KITTITAS COUNTY DEPARTMENT OF PUBLIC WORKS

MEMORANDUM

TO: Jeff Watson, Community Development Services
FROM: Christina Wollman, Planner II *W*
DATE: October 25, 2010
SUBJECT: BL-10-00036 Ragland

The Public Works Department has reviewed the Request for Boundary Line Adjustment Application. In order to ensure that it meets current Kittitas County Road Standards, the applicant needs to provide the following prior to final approval:

TAX LOT SEGREGATION		
PREPARED FOR FRANK RAGLAND		
PTN. OF THE NORTH 1/2 & THE WEST 1/2 OF THE SW 1/4, SEC. 1, TOWNSHIP 18 NORTH RANGE 17 EAST, W.M. KITTITAS COUNTY WASHINGTON		
DWN BY	DATE	JOB NO.
D. PIERCE	09/2005	05501
CHKD BY	SCALE	SHEET
D. NELSON	1"=400'	1 OF 2

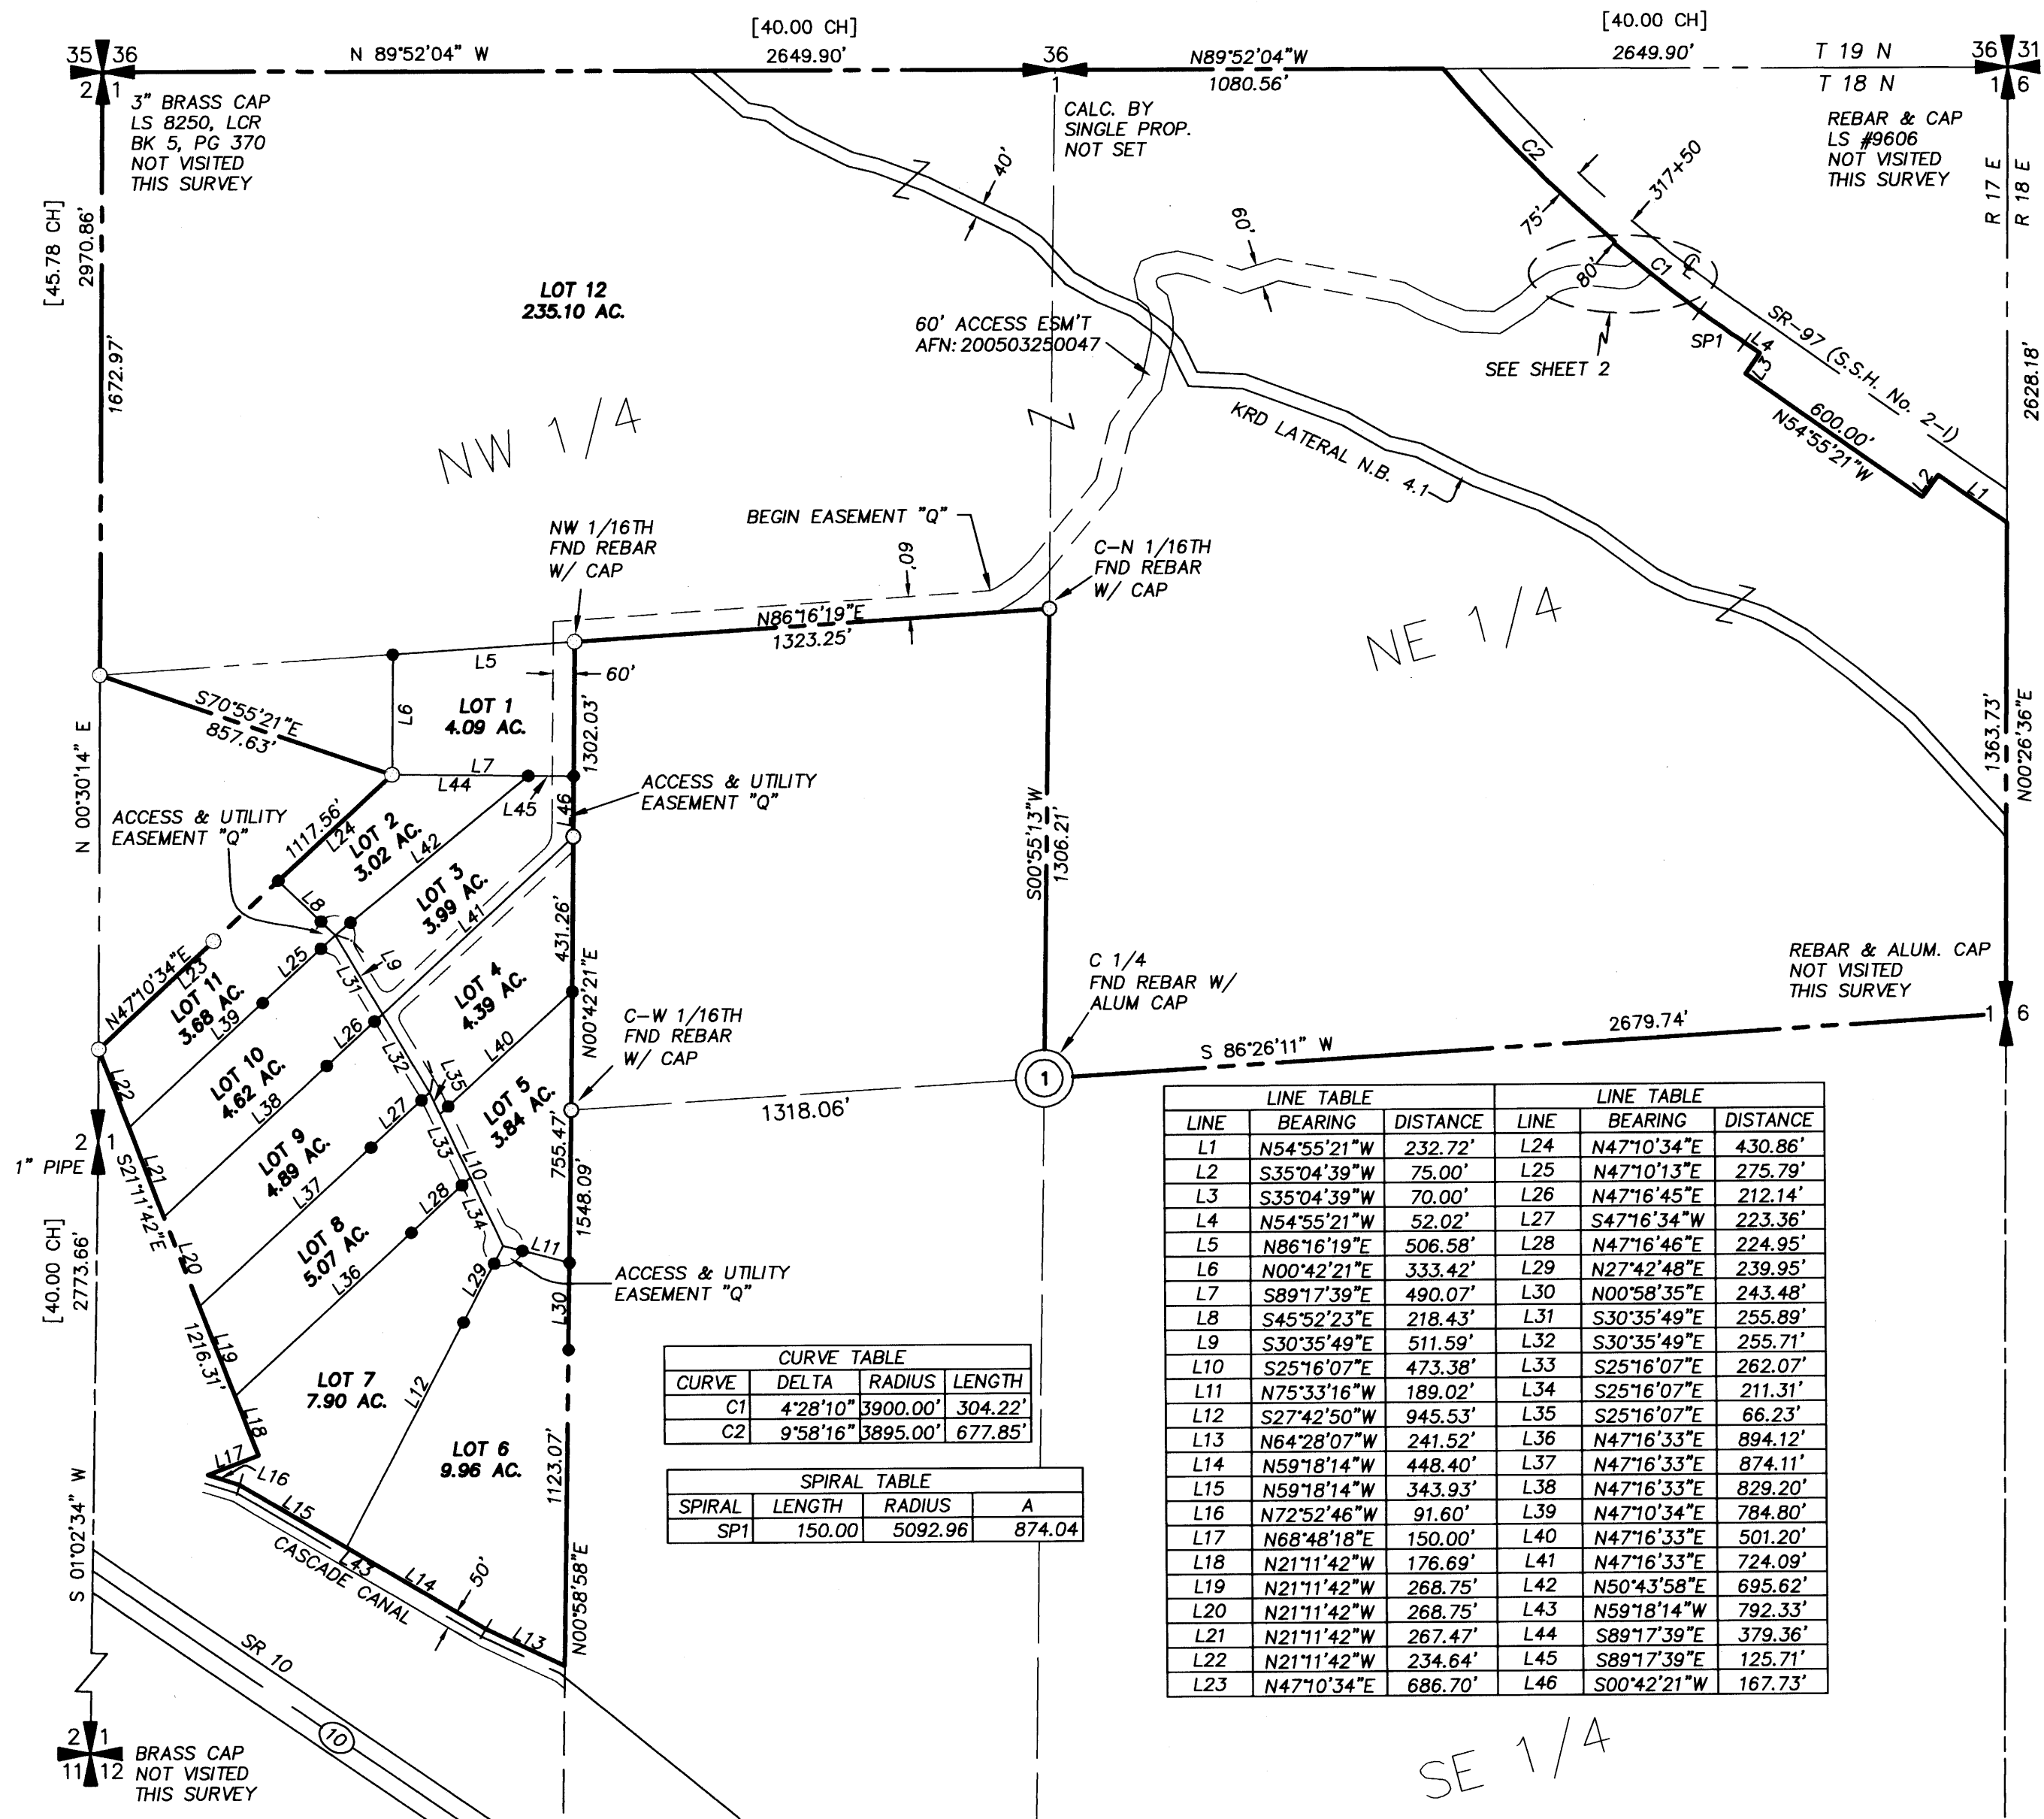
1. The proposed access with appropriate easement(s) shall be shown and shall conform to applicable Kittitas County Road Standards.
2. A revised legal description that describes the final configuration of the subject property shall be required.
